re: PLANNING BR/80/17/PL

With reference to the above, I am writing to express my concern about the proposed building of a bungalow next to the Pumping Station in this Close.

PROPOSED GROUND FLOOR PLAN
& SITE BLOCK PLAN.

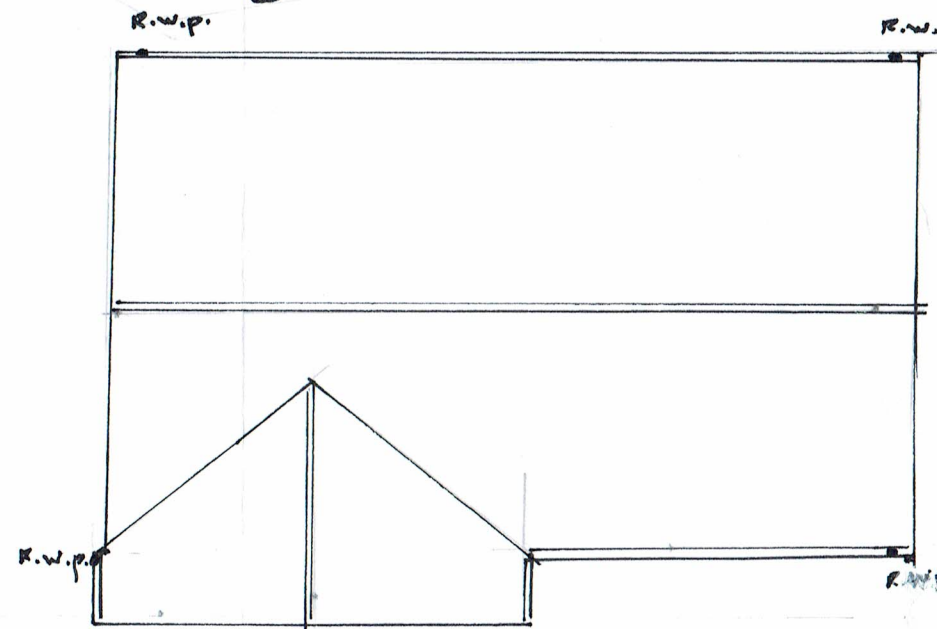
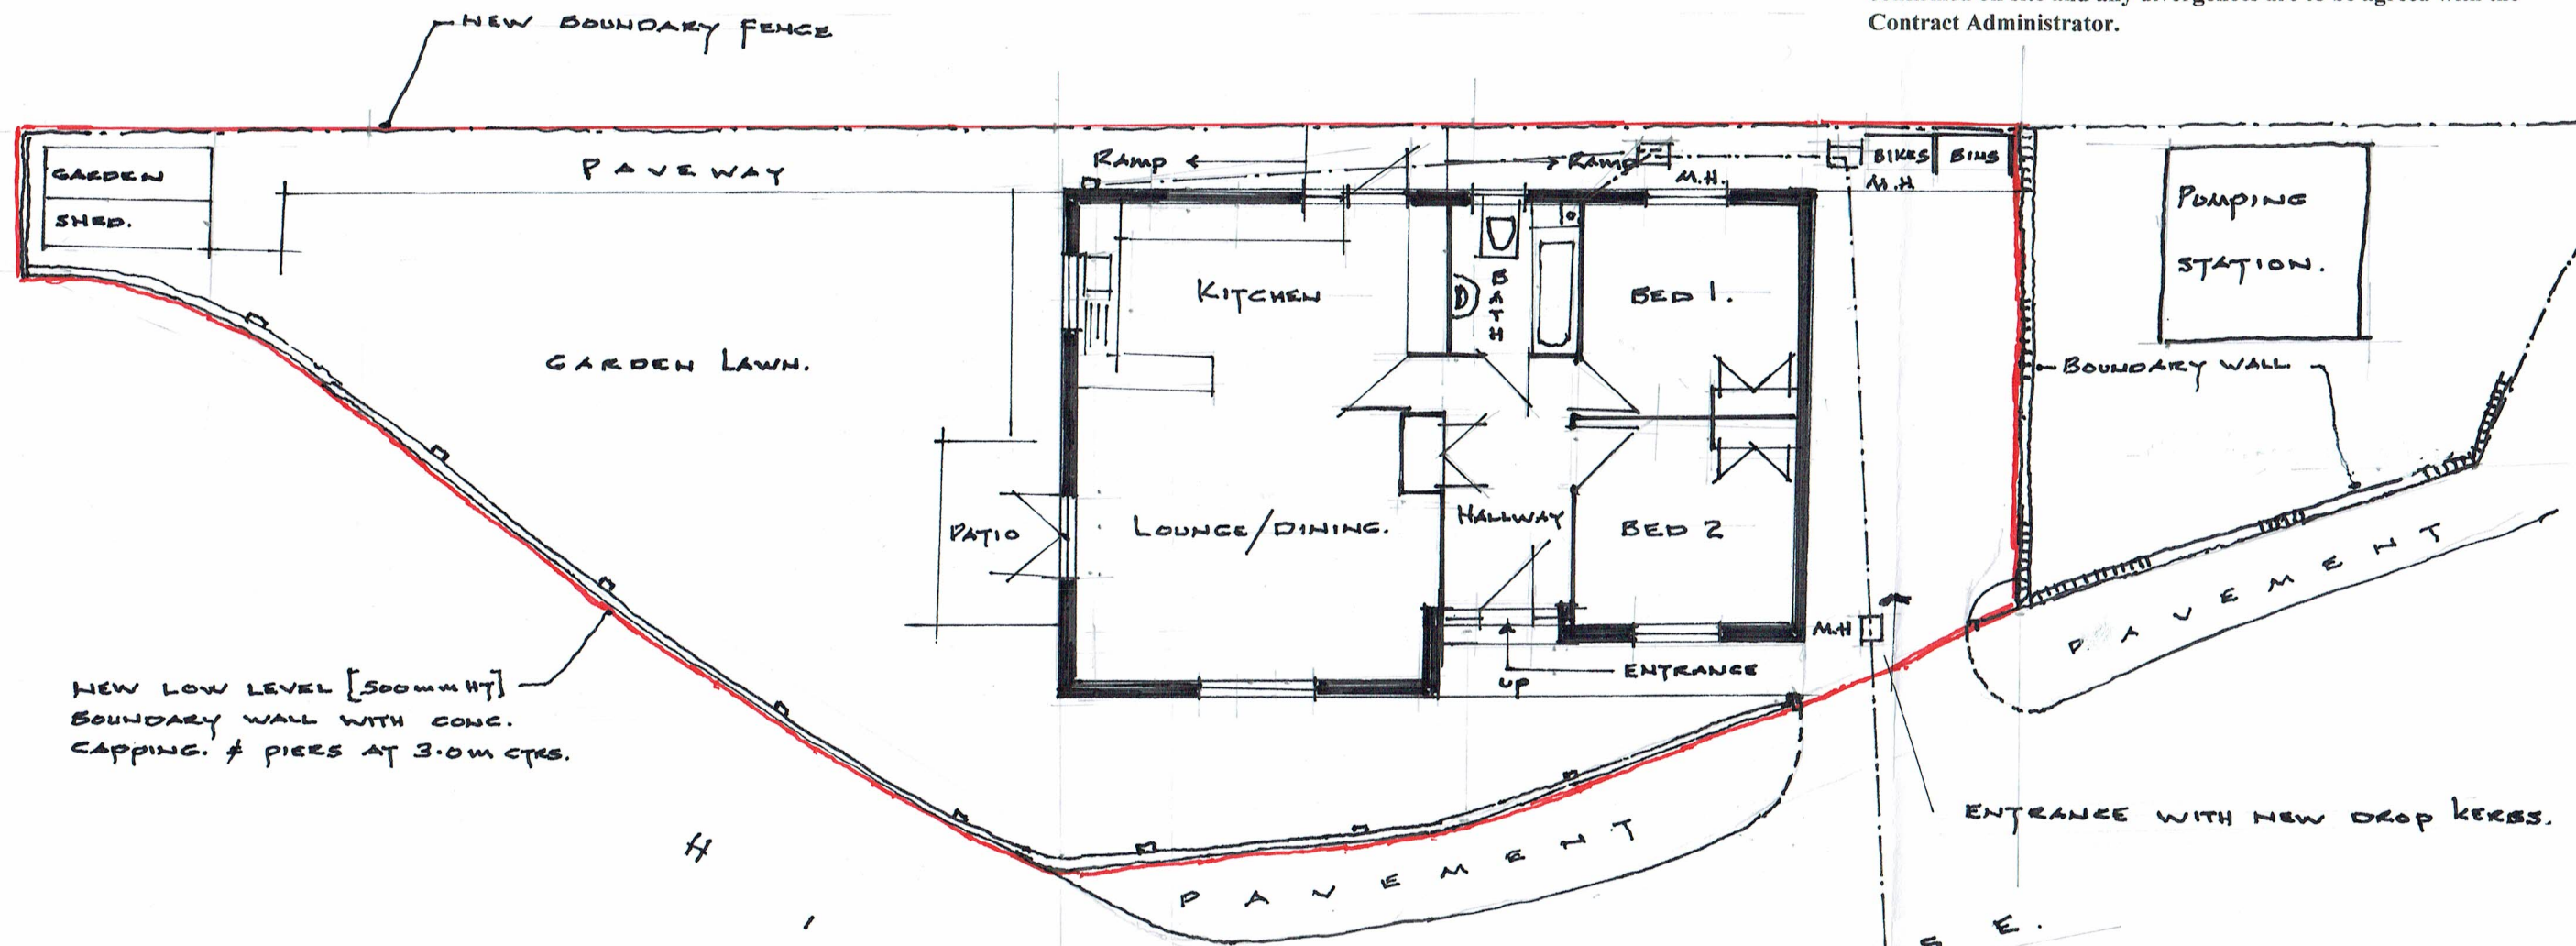
1. Flooding risk as this land is in a flood ZONE 3 area.
2. As there would be only parking for one car, I am concerned that any on-road parking would make problems for us and refuse collectors etc -

3. Garden area is very small and the boundary wall so low that we will lose a bit of privacy when people use the garden in the new bungalow.
4. The bungalow is so close to the Pumping Station & could be affected by noise, vibration & smell.
5. Site slopes North to South & would require work to bring up to level.
6. All bungalows in close have lounge & kitchen at the rear. New bungalow has lounge/diner at front & therefore would overlook bedrooms.
7. There is a variety of wildlife on the allotments which could be in danger from new building.
